## Comments on the Applicant's D1 Submissions

This document sets out the comments by Cambridgeshire County Council (**CCC**) and Fenland District Council (**FDC**) (together, **the Councils**) on the Applicant's Deadline 1 (**D1**) submissions. The tables below set out the document in question that the Councils are commenting on, together with the relevant paragraph or reference number.

March 2023

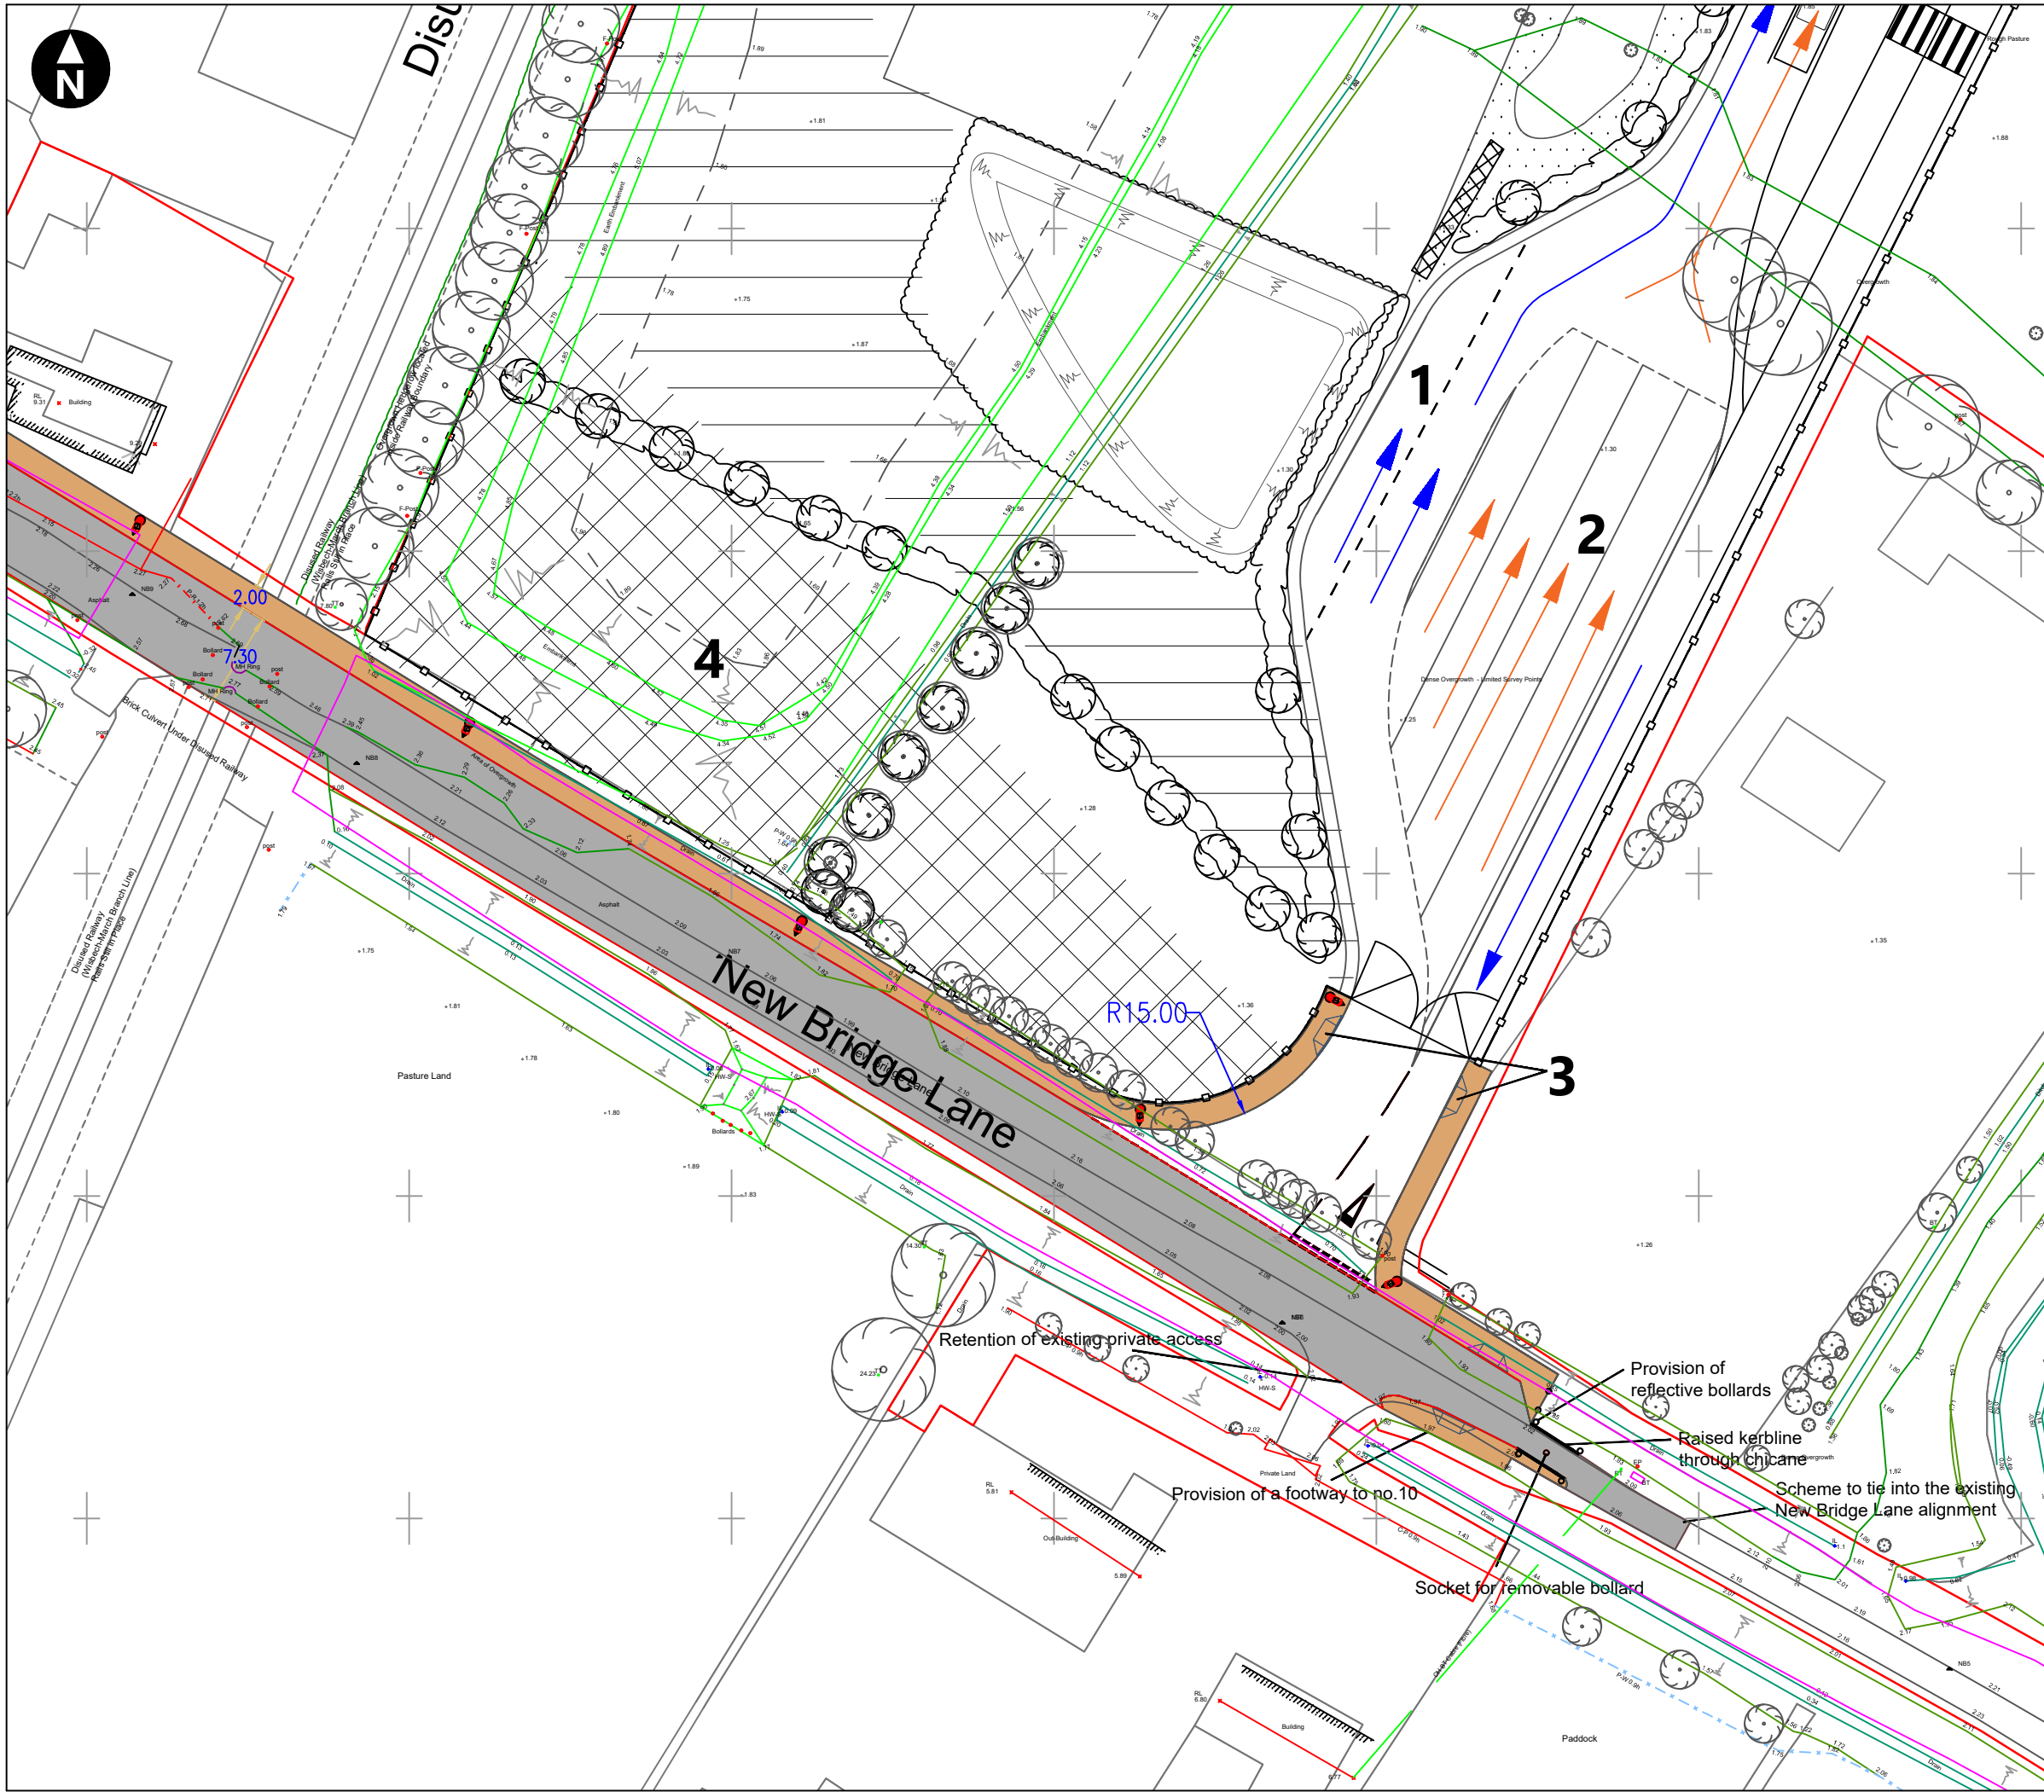
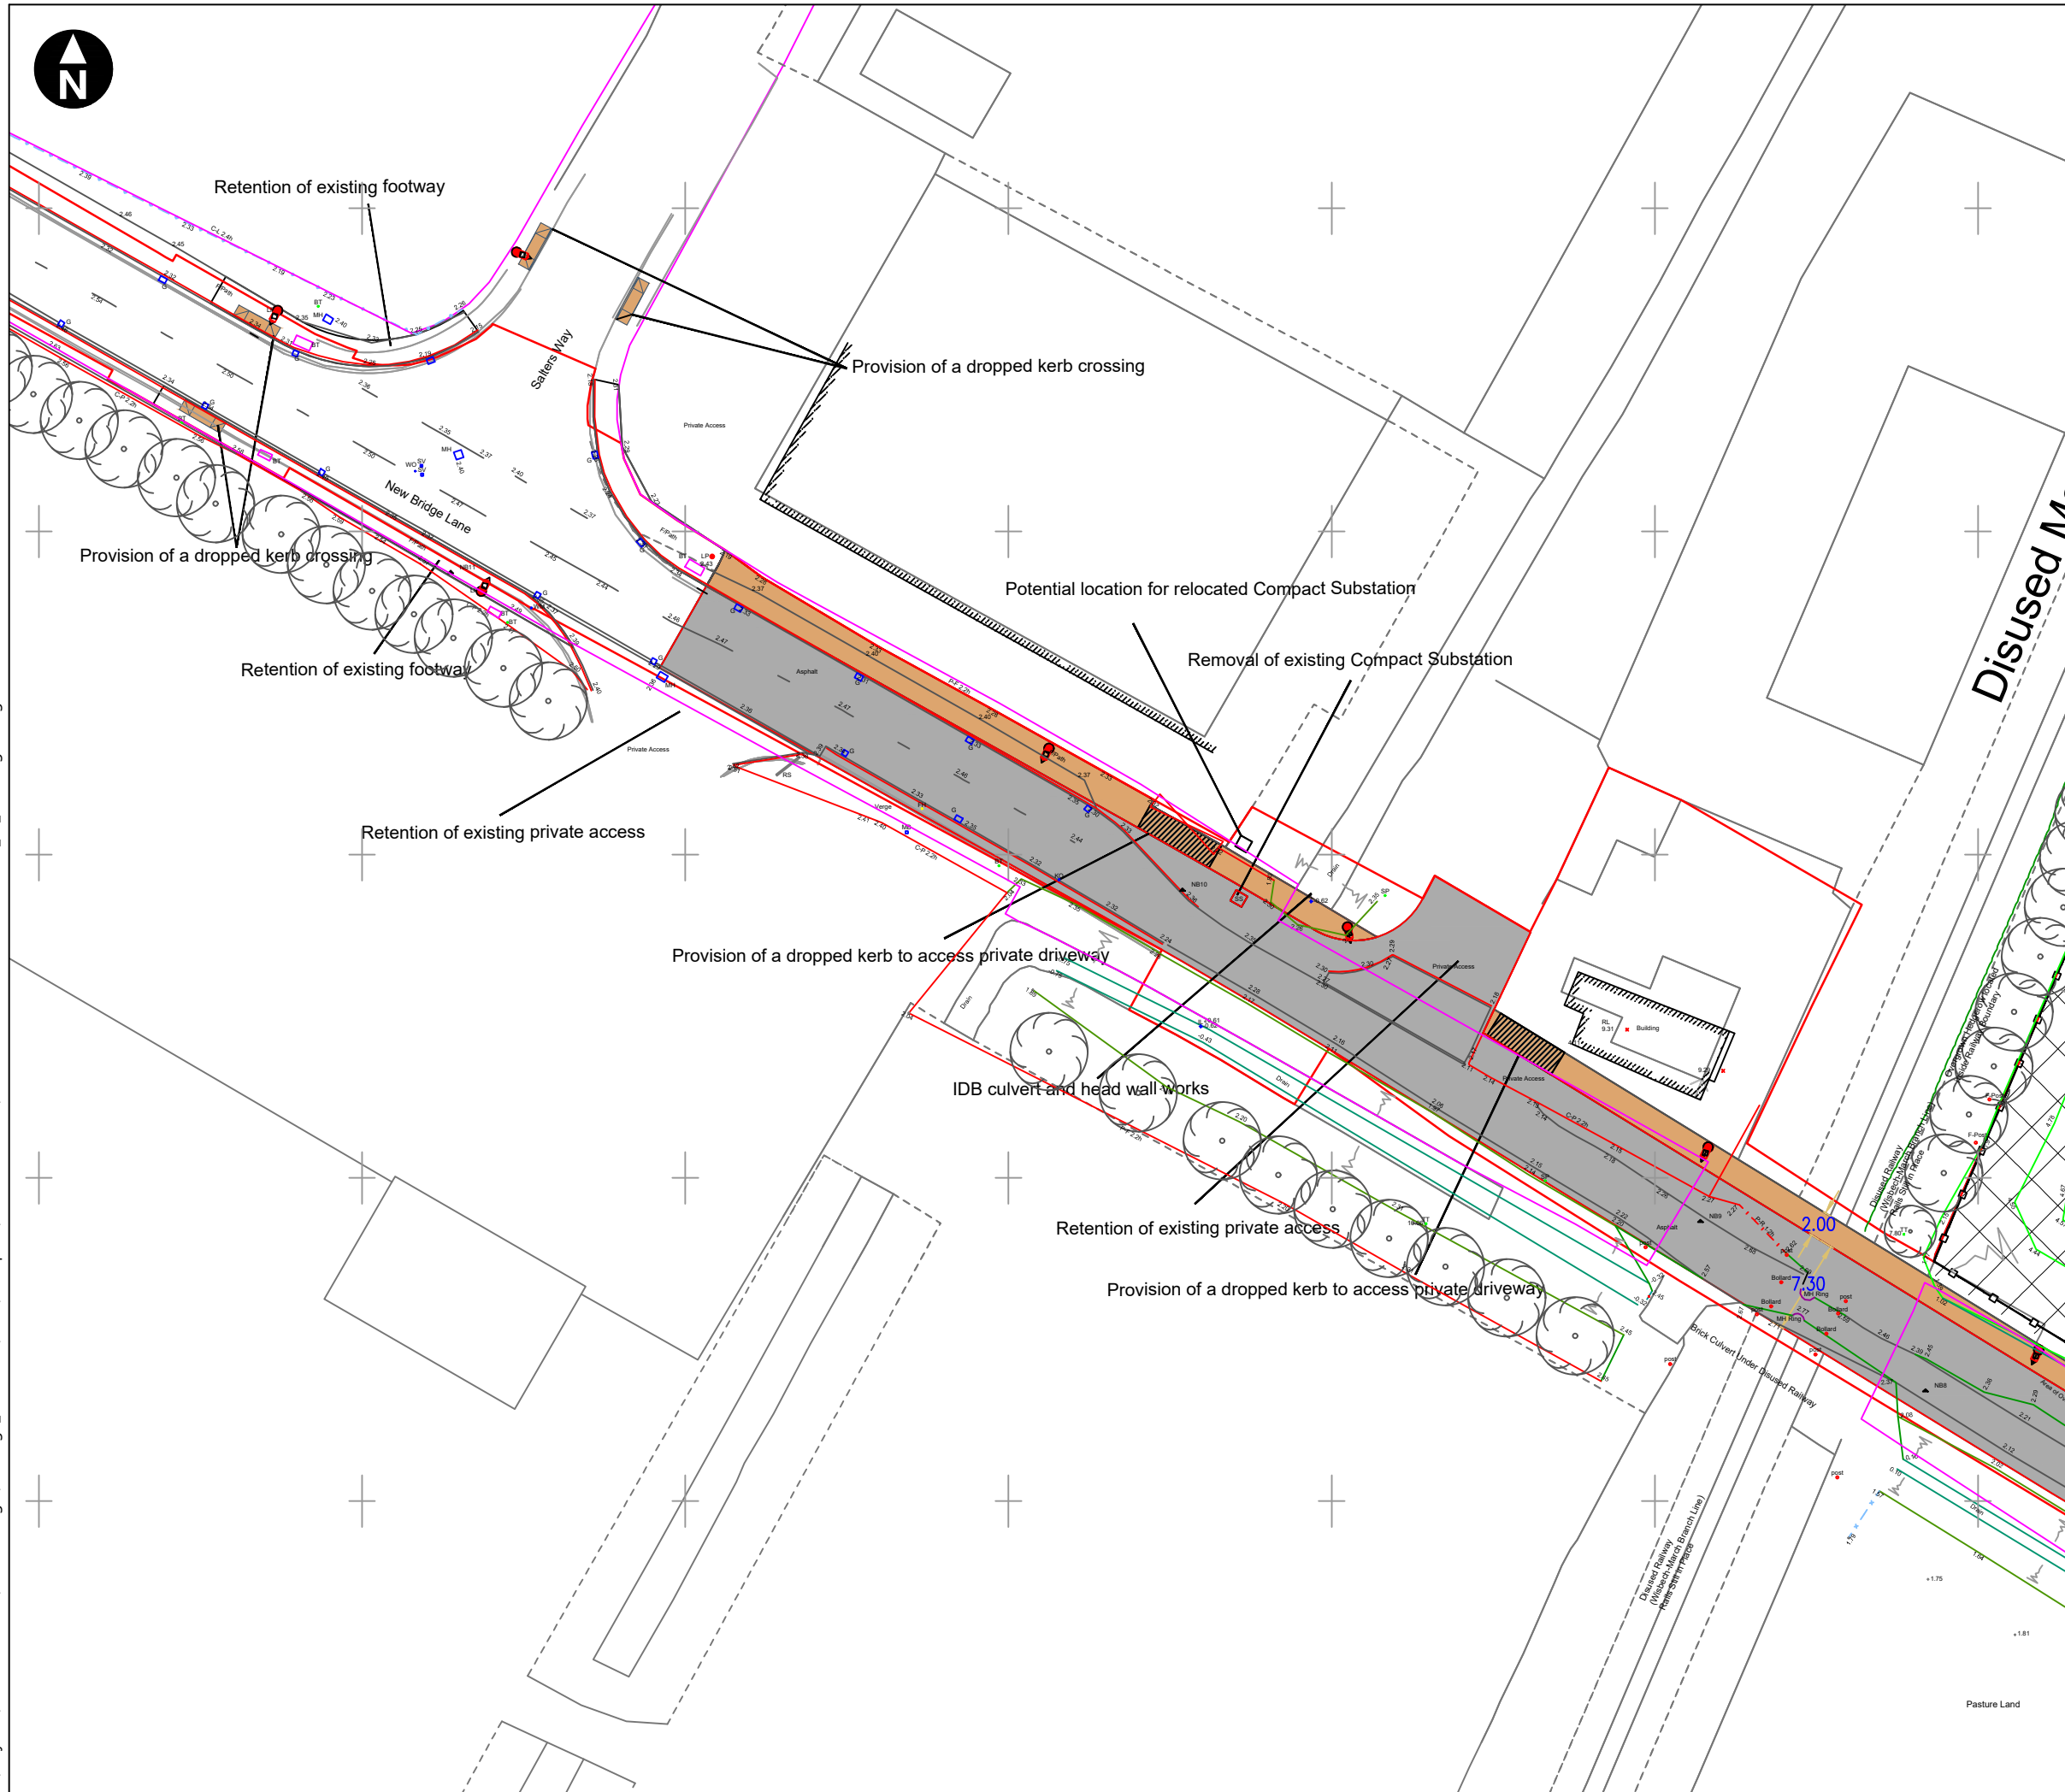
Topic	Paragraph Number	Councils' Comment
Non-motorised users	General	The Outline CTMP does not provide any detail on how access will be preserved for non-motorised traffic that uses New Bridge Lane and the former level crossing as a through route. The Councils request that detail is provided on this.
Damage to highway network	General	<p>The outline CTMP does not address the issue of damage to the wider highway network for which CCC is responsible. It is noted that there is provision for the inspection of access points to the highway to be used by construction vehicles.</p> <p>It is requested that provision be made for “before”, “during” and “after” inspections of the wider highway network to be affected by construction traffic. The methods of these inspections are to be agreed with CCC and the inspections funded by the Applicant.</p> <p>It is further requested that provision be made for the Applicant to fund any highway maintenance works that are required to remedy damage caused by construction traffic to the wider highway network.</p>
